Arun District Council Planning Department

11th December 2019

These are my objections to BE/OUT/109/19 in full, in support of my statement on line-OWPC25289.

Fig. 6.2 - Extract from Transport Statement – Visibility Splays & Junction Arrangement

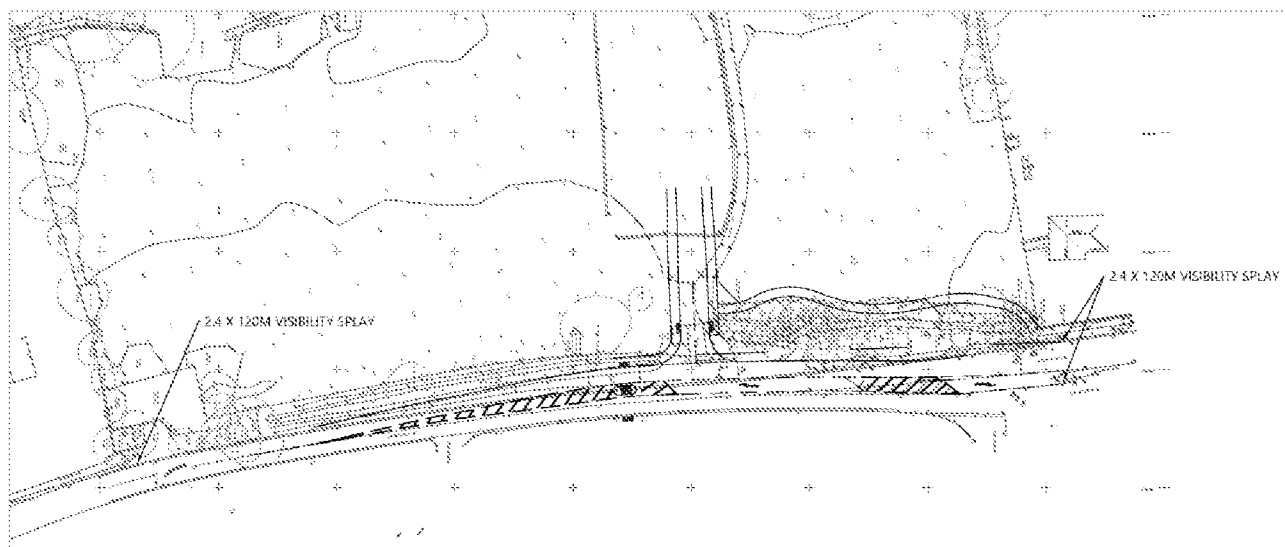
- The proposed "ghost island" giving the access into this development is at the narrowest and lowest lying point of the A29. Here, it is way too close to the hatched area for the turning into Shripney Lane. In the plans-it truncates our safe approach.

The photographs of the road, supplied by the developers, are deceptive- due to the camera lens used. It looks as though there are straight approaches of road with good, clear views, where the access to the development will be situated. I would ask for the access point to be reviewed and possibly relocated, for reasons of road safety.
